Project Name: MESA PARK ADDITION

CITY OF ALBUQUERQUE  
 PLANNING DEPARTMENT  
 September 3, 2008  
 DRB Comments

**RE: Tract A-1, Block 2, Mesa Park Addition**

**Re: Sketch Plat Submittal**  
**Replat of Tract A-1 in Block 2 of Mesa Park Addition**  
**Southeast corner of Arizona Street SE and Zuni Road SE**

EXISTING CONDITIONS

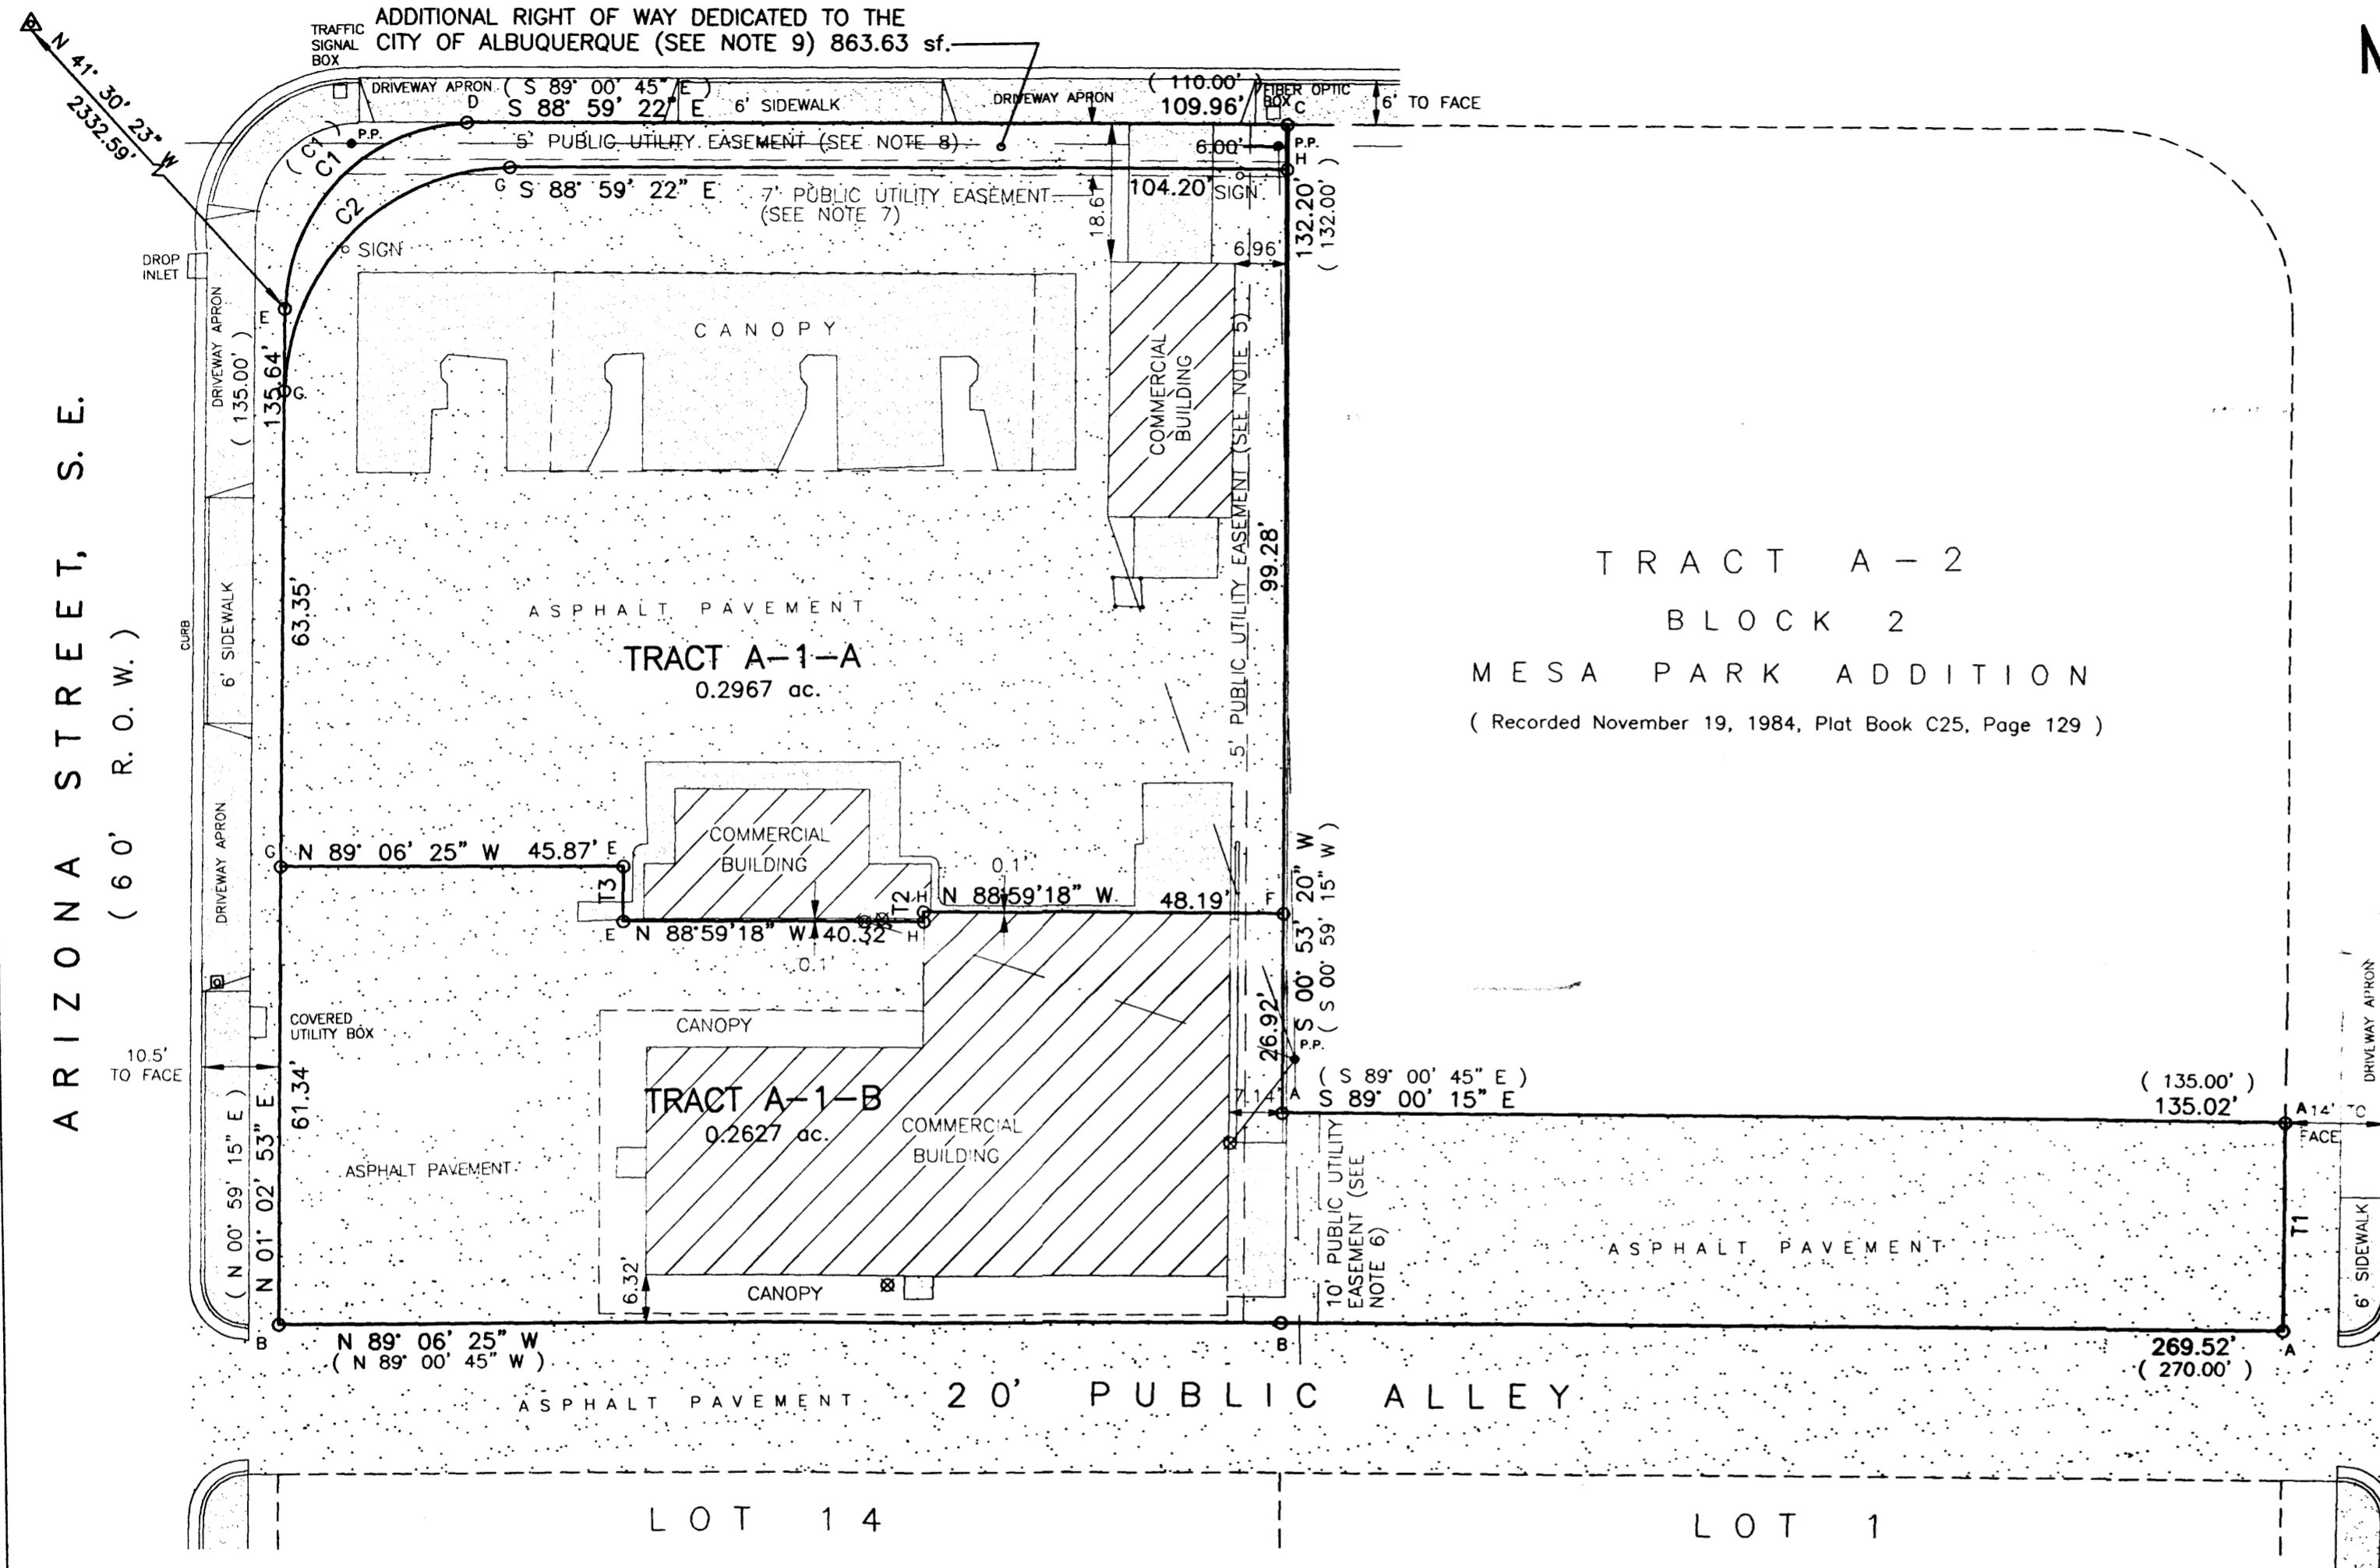
PLANNING (Last to sign): - AMAFCA signature  
- verify no openings within 3' of property line

I have visited the site referenced above and I have observed that there are no door or window openings in either building along the demising property line.

INDEXING INFORMATION FOR COUNTY	DRAWN: T R J	SCALE: 1" = 20'	FILE NO. SP-8-02-2008
OWNER: - LOCATION: SEC. 24 T.10 N., R.3 E., N.M.P.M. MESA PARK ADDITION	CHECKED: T D J	DRAWING NO. SP80208.DWG	SHEET 1 OF 2
		19 AUG 2008

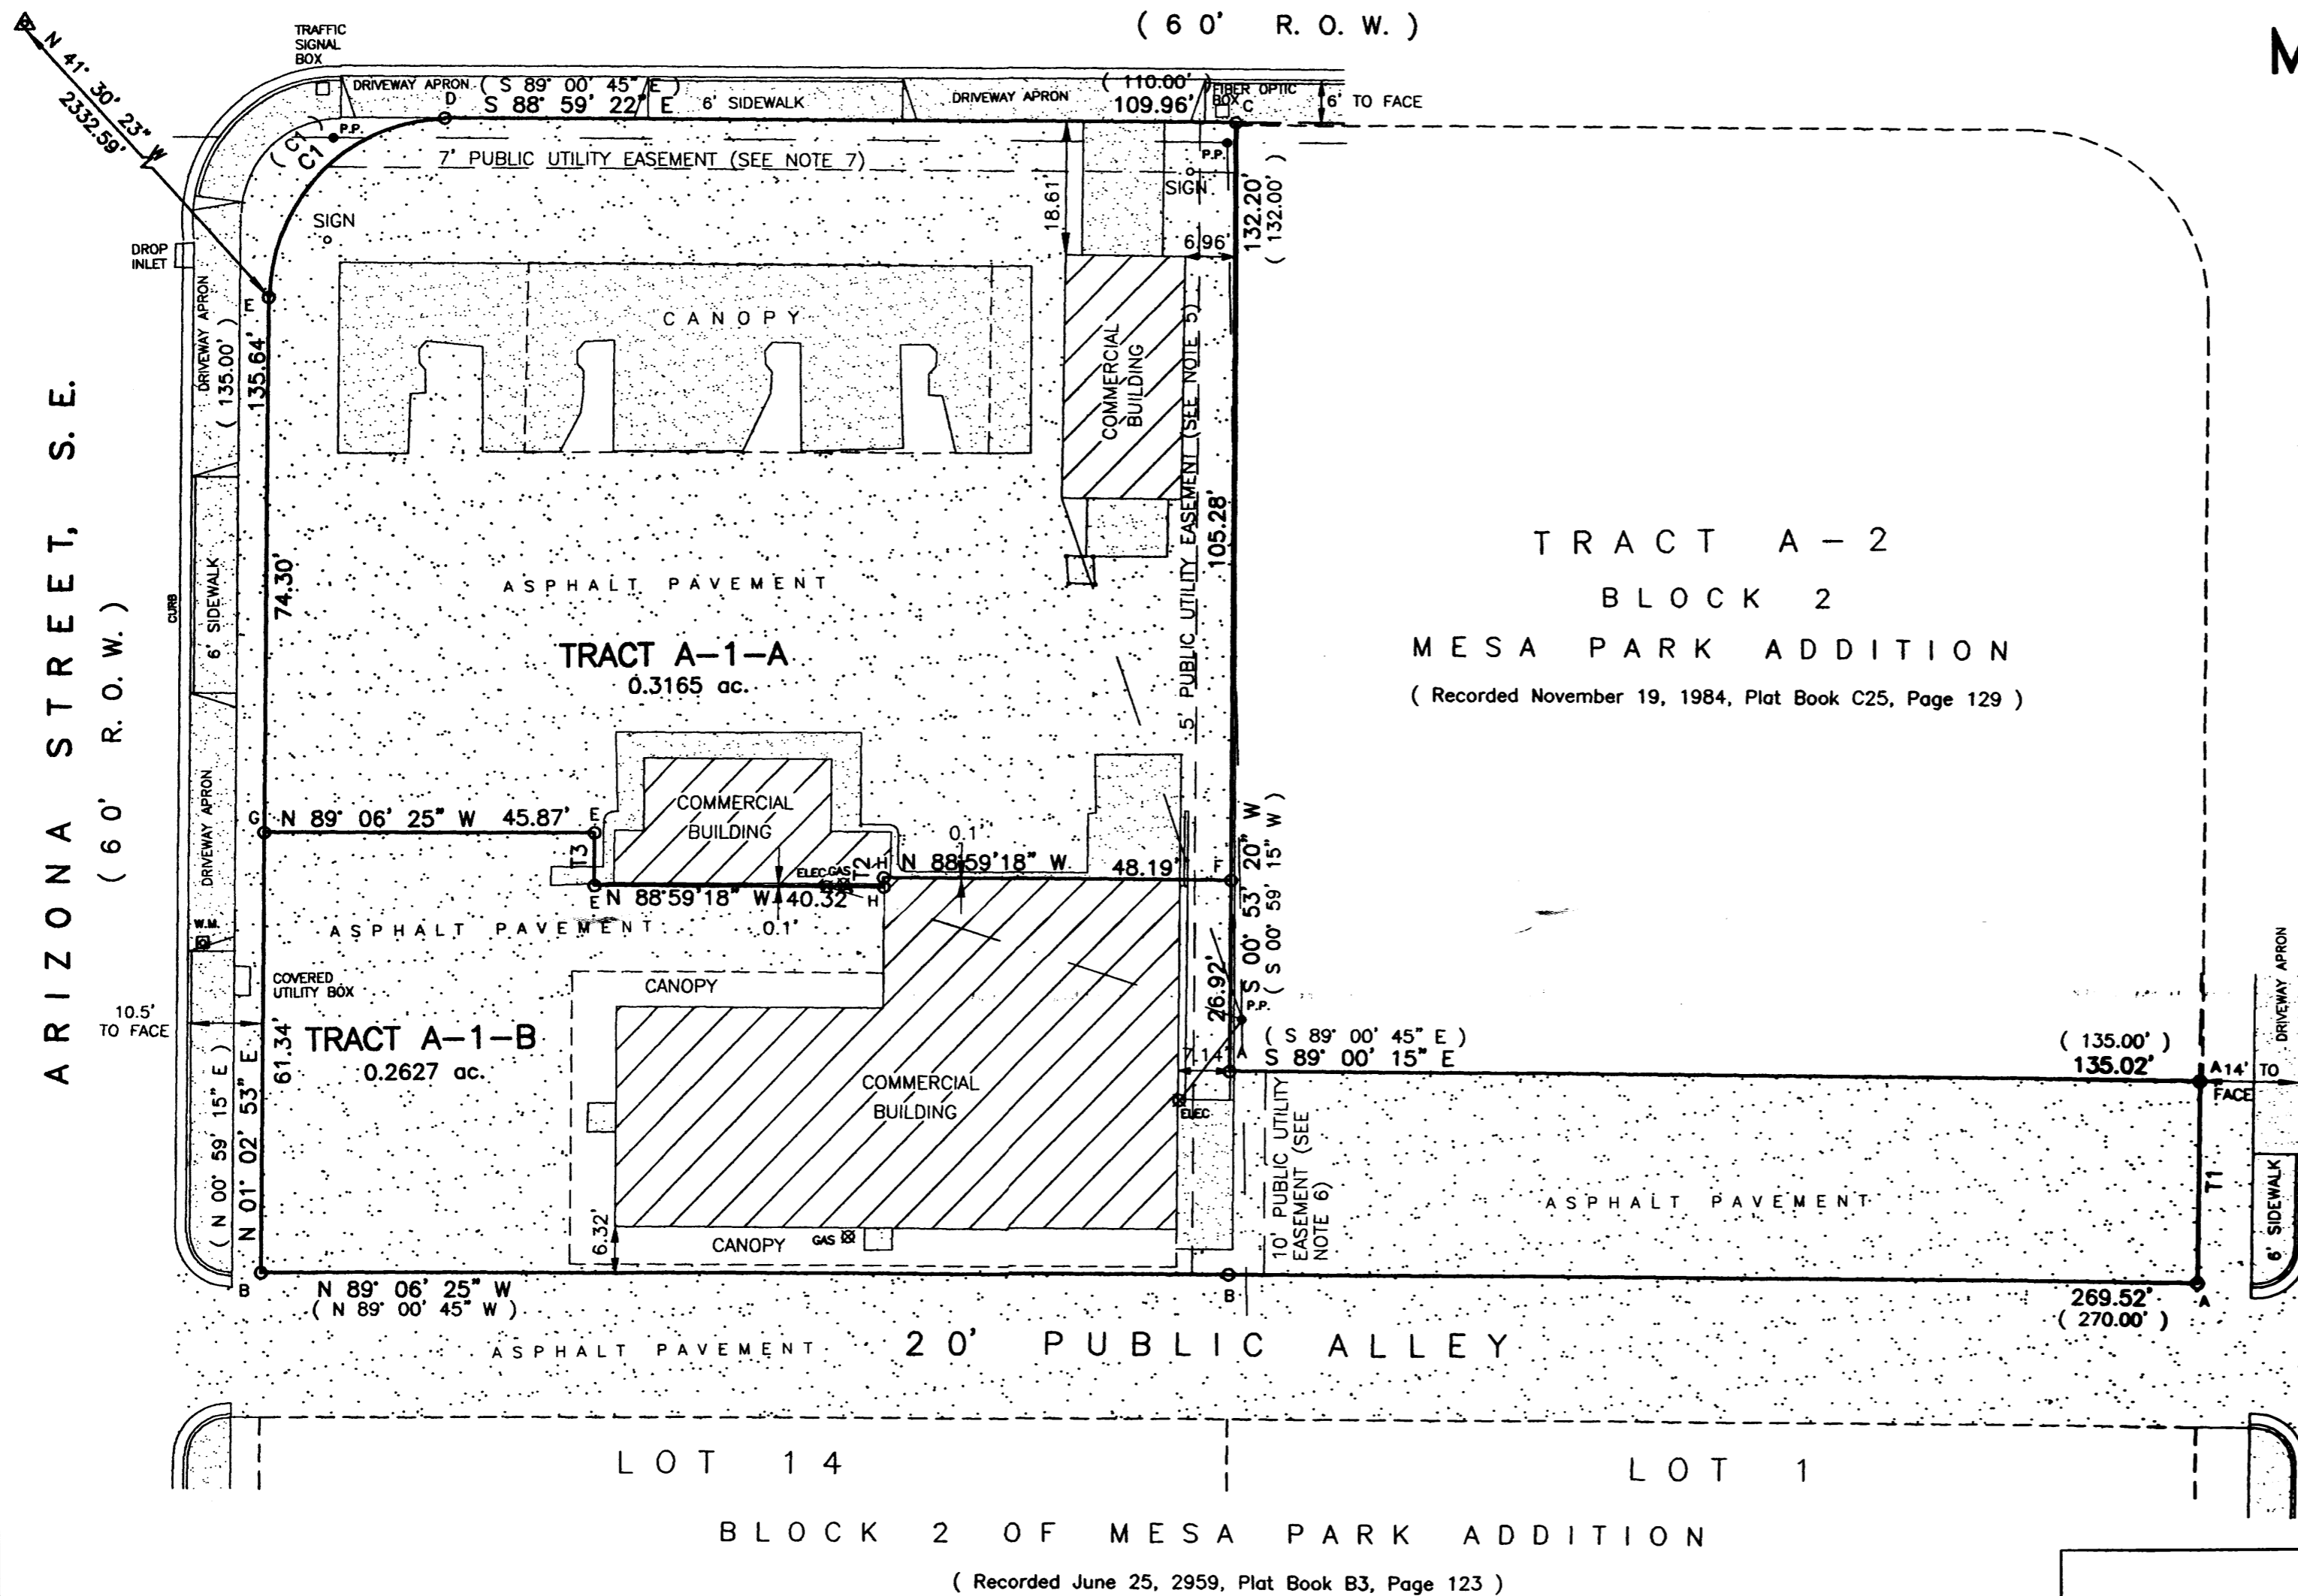
A site plan that shows parking (and parking calculations) is needed to demonstrate that each lot can individually meet zoning requirements. Certification will be needed to demonstrate compliance with the Building Code vis a vis the proposed lot line. It appears reciprocal access and drainage easements will be needed. A solar collector note per Section 14-14-4-7 of the Subdivision Ordinance will be needed.

Regarding your comments from sketch plat hearing, September 3, 2008: I have included parking calculations showing the existing parking for the southerly building. I have also included a letter from a contractor certifying that the structures are one-hour fire rated along the boundary line.
